## **TR020001 Luton Airport Expansion**

### **Summary of Written Representations prepared by The National Trust for Places of Historic Interest or Natural Beauty (reference number 20040696)**

**TR020001 Luton Airport Expansion  
Procedural Deadline 1 Submission: Written Representation**

Drawing Title
**Figure 16.1
 Air Noise and Surface Access Noise Study Area**

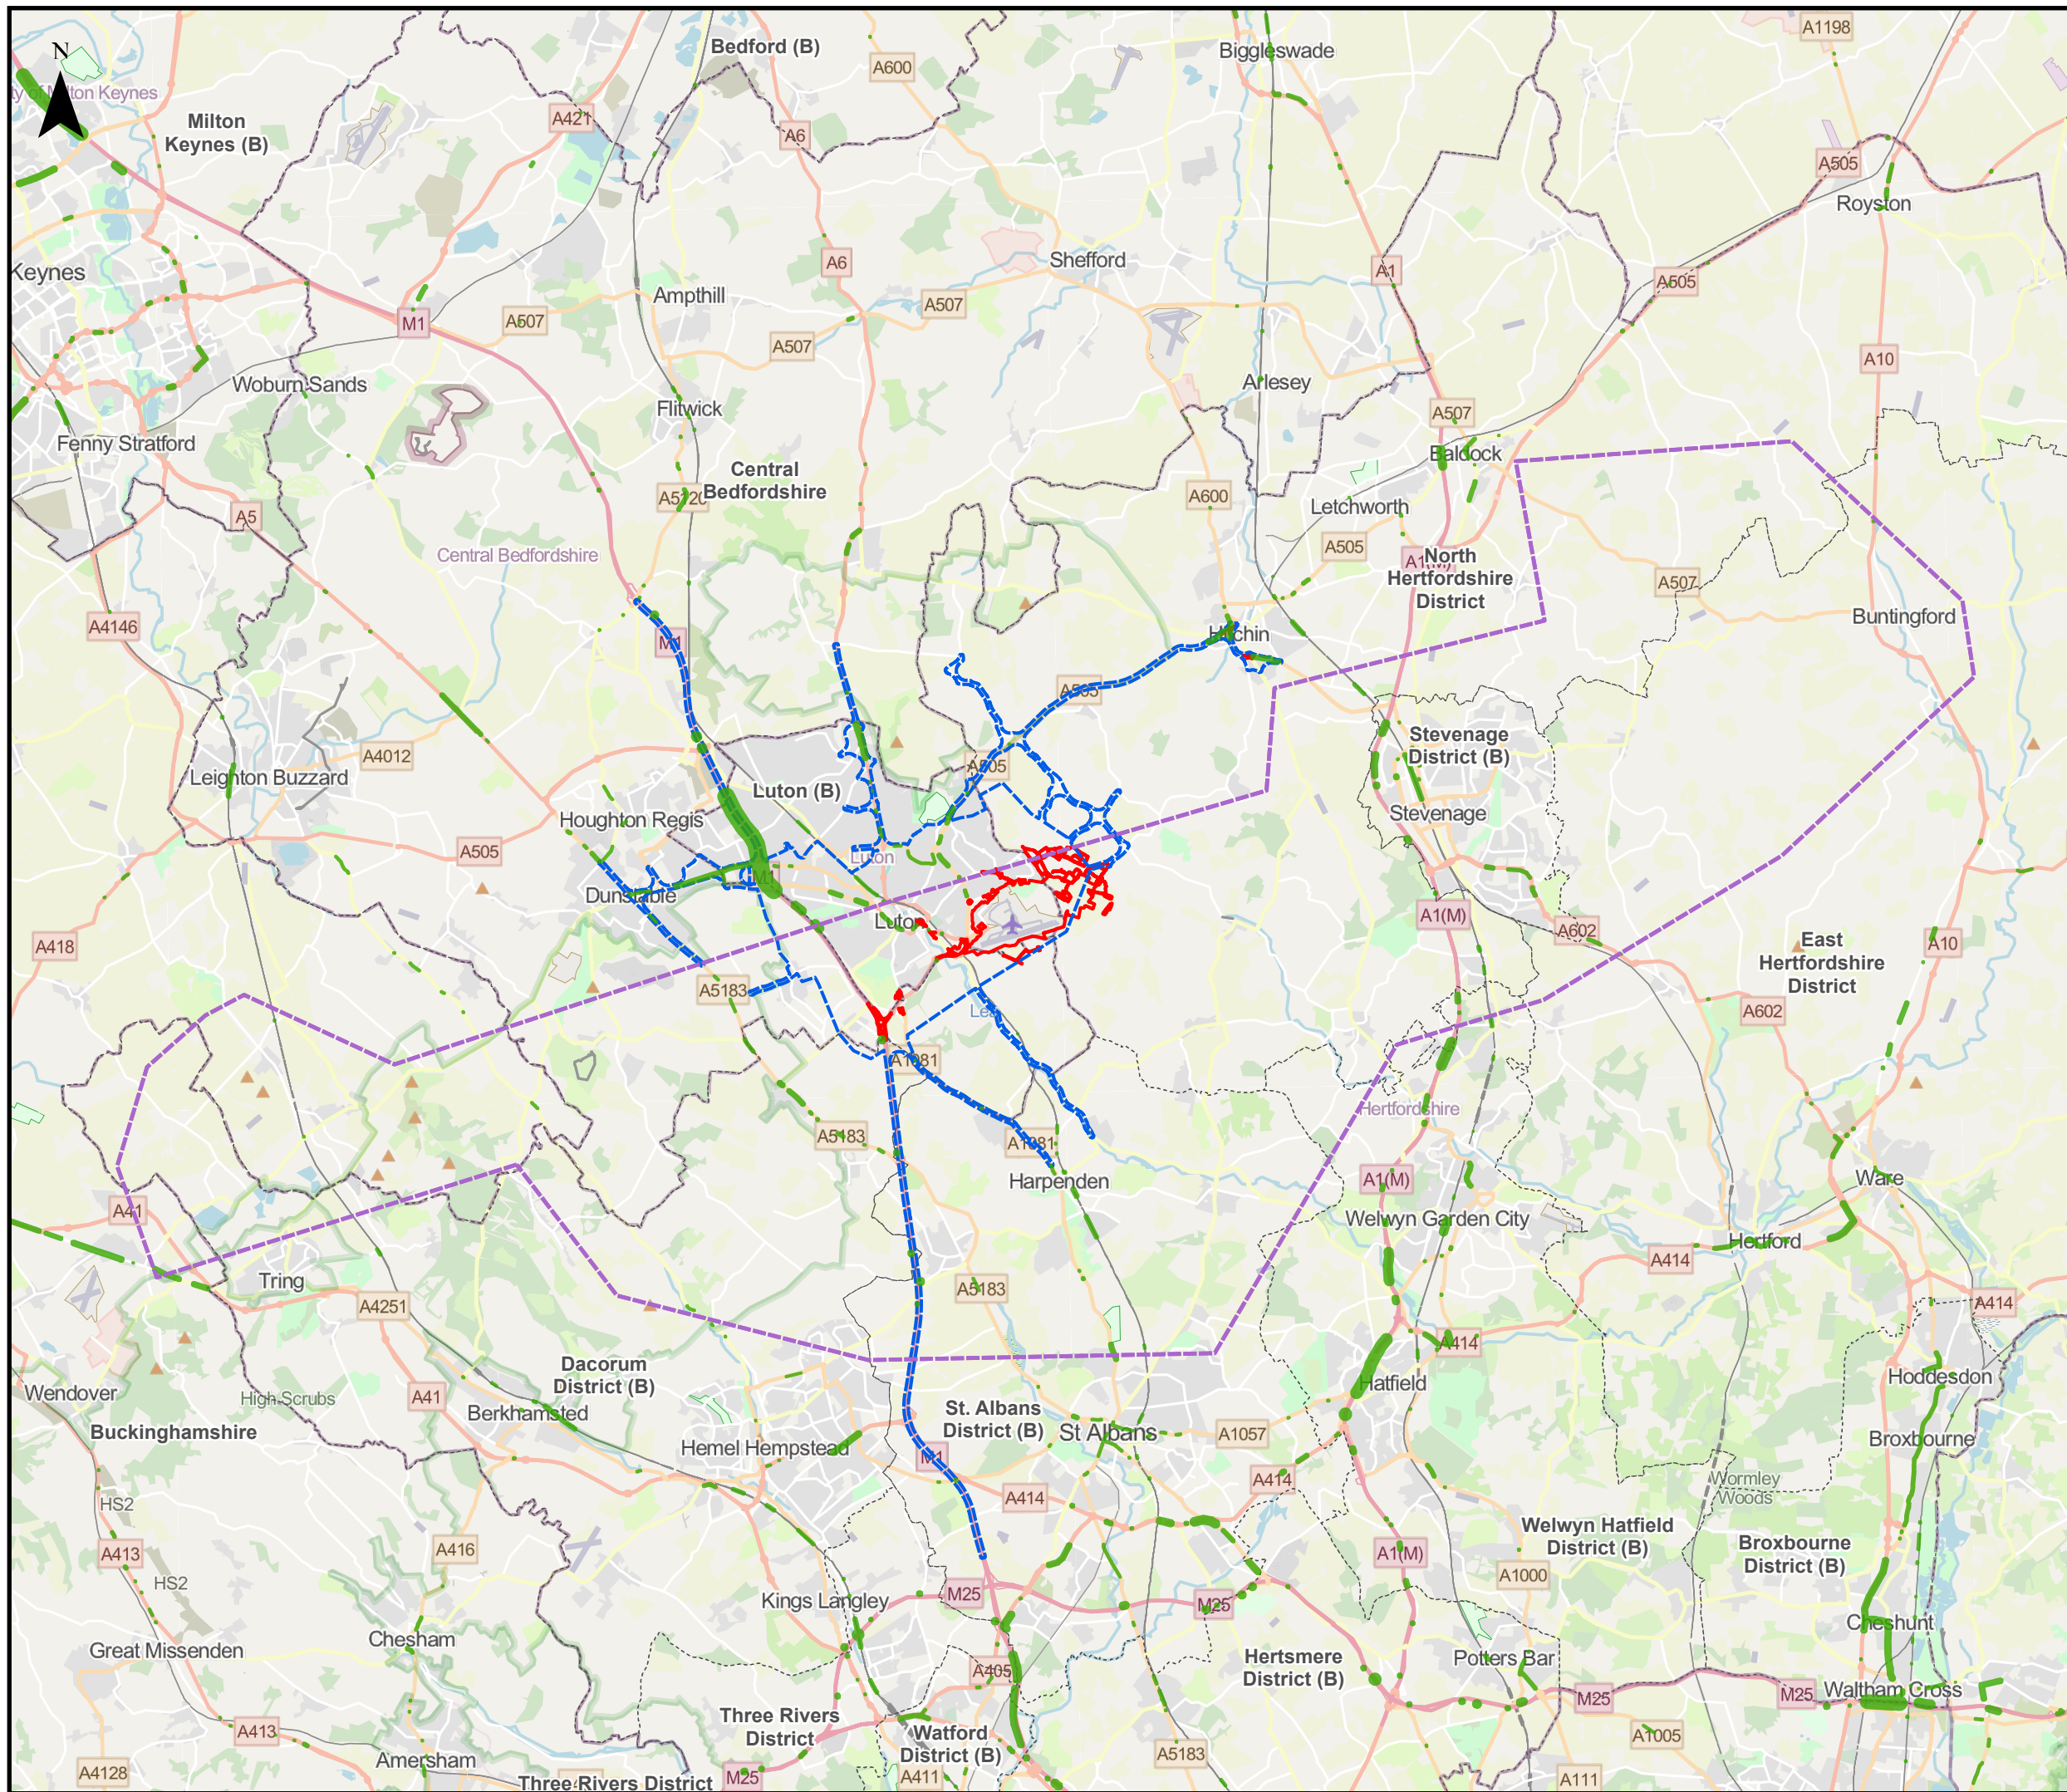
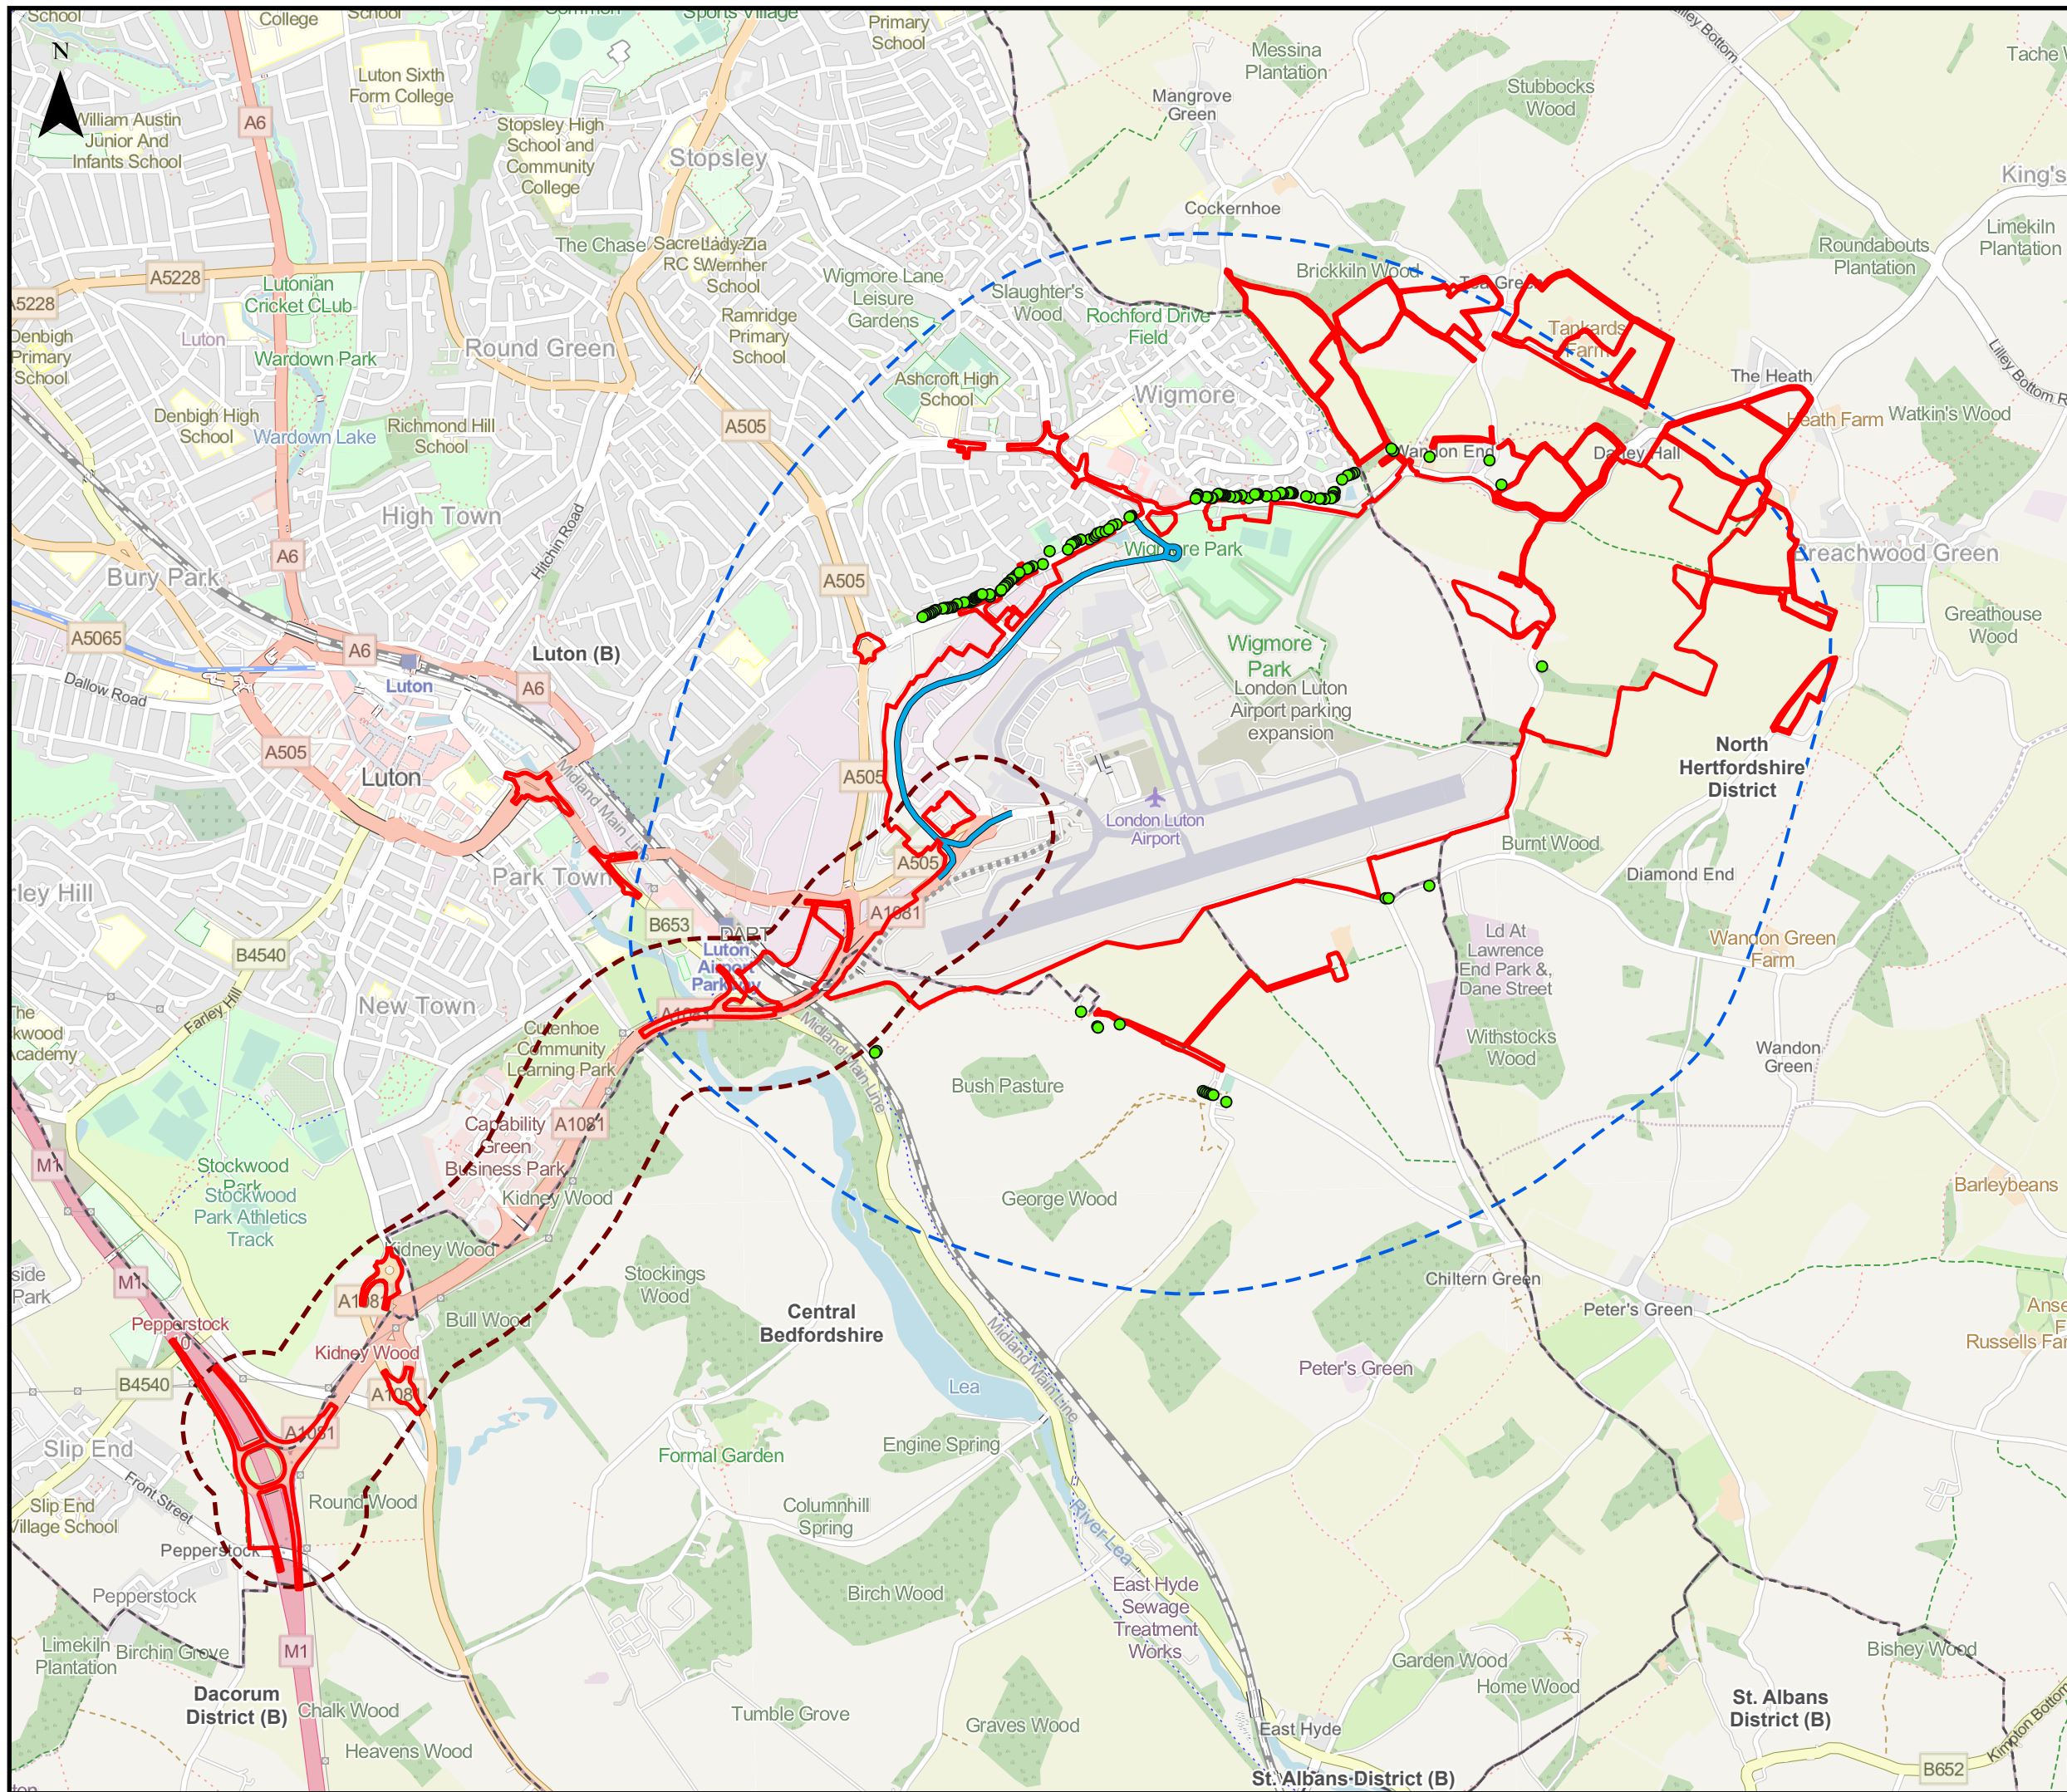
Paragraph 16.3.9 of the ES Chapter on Noise defines the air noise study area, which is the area over which aircraft noise level predictions have been undertaken, as follows: “The study area for air noise has been defined based on guidance within Air Navigation Guidance, which states: “Below 4,000 feet, there is a strong likelihood that aircraft could create levels of noise exposure above the LOAELs identified above, which is reflected in the Altitude Based  
Cont/d

Priorities". In addition, the largest of the baseline and Do-Something (defined in paragraph 16.5.48) daytime and night-time LOAEL air noise contours across all assessment scenarios have been used to define extents of the air noise study area. The Air Noise Study Area is illustrated in Figure 16.1 of this ES [TR020001/APP/5.03]."

The above quote refers to the Lowest Observed Adverse Effect Level (LOAEL), which is a term adopted from the Noise Policy Statement for England (NPSE) and is defined as "the level of noise exposure above which adverse effects on health and quality of life can be detected". The LOAELs for operational air noise are taken from the Air Navigation Guidance (Department for Transport, 2017) and are 51dB LAeq,16h for daytime noise. This is adopted from research into the health-related effects of aircraft noise undertaken by the UK Civil Aviation Authority (CAA) (Survey of Noise Attitudes 2014: Aircraft Noise and Annoyance, Second Edition). This survey showed that annoyance-related adverse effects can occur down to levels of around 51 dB LAeq. Whilst the LOAEL is appropriate to use for assessment with relation to the objectives of the NPSE, it may not capture the potential for all adverse effects on National Trust sites, as these are not necessarily health-related, but defined as a potential disturbance of setting, including tranquillity where relevant.
